Online Comment

Application H16-0376-18
Location 240 PARK ROAD SPALDING PE11 1QZ
Proposal Side-extension and single-storey rear extension

proposed ground floor

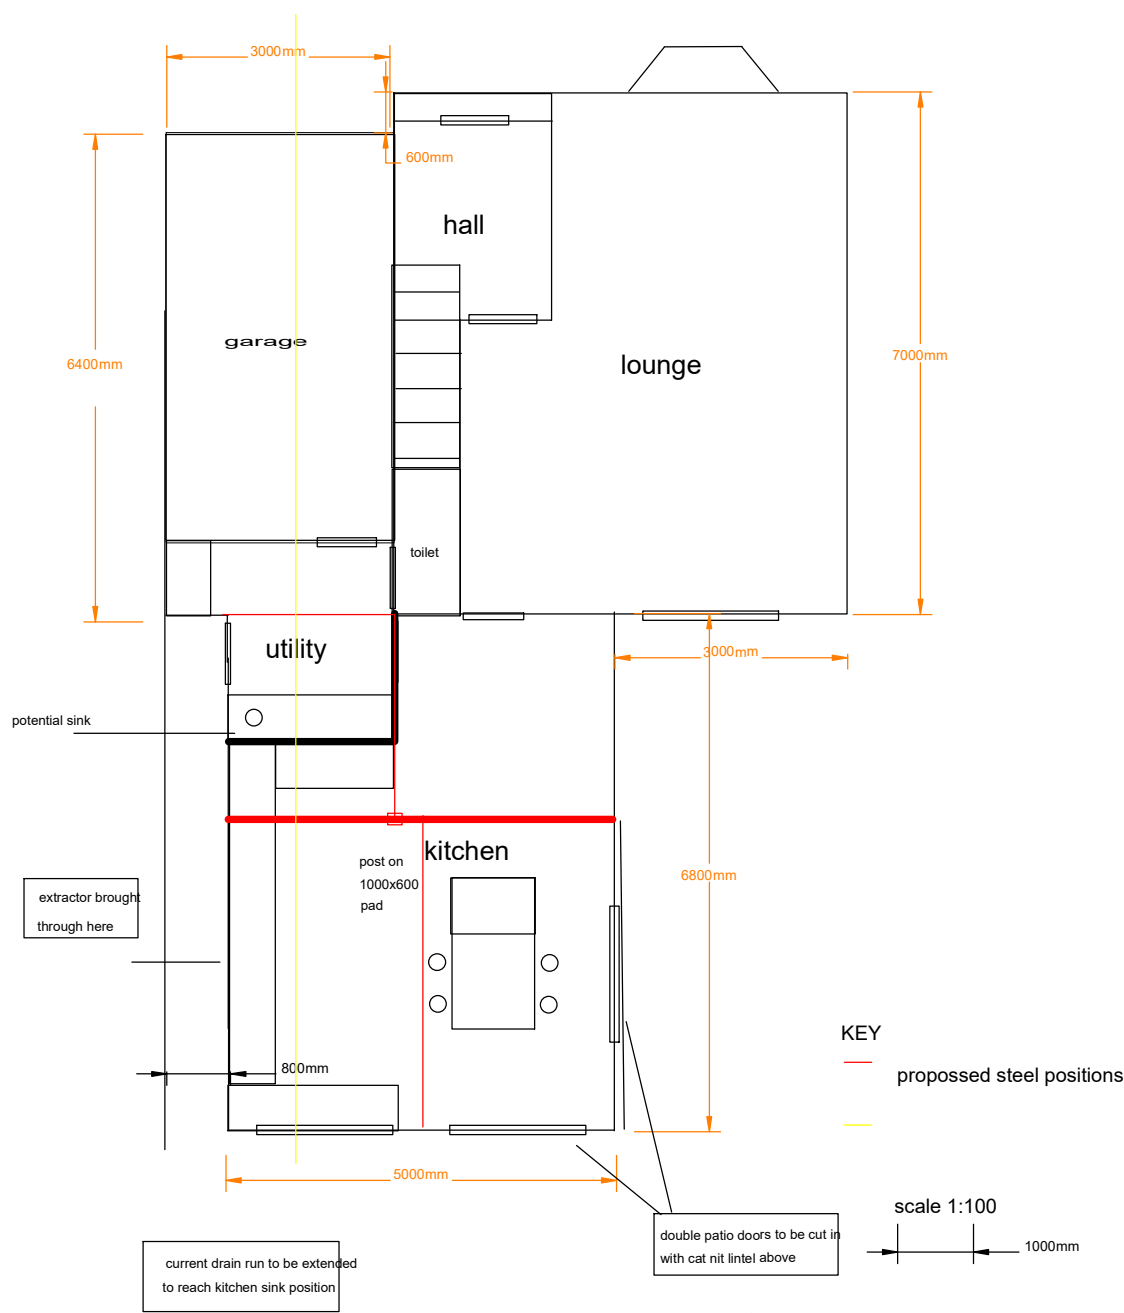
The fascia boards do not harmonise with the rest of the building or with other houses in Park Road. Brick would be appropriate. The new upstairs window should resemble the others. We also wonder why the roof line is different on the proposed extension.
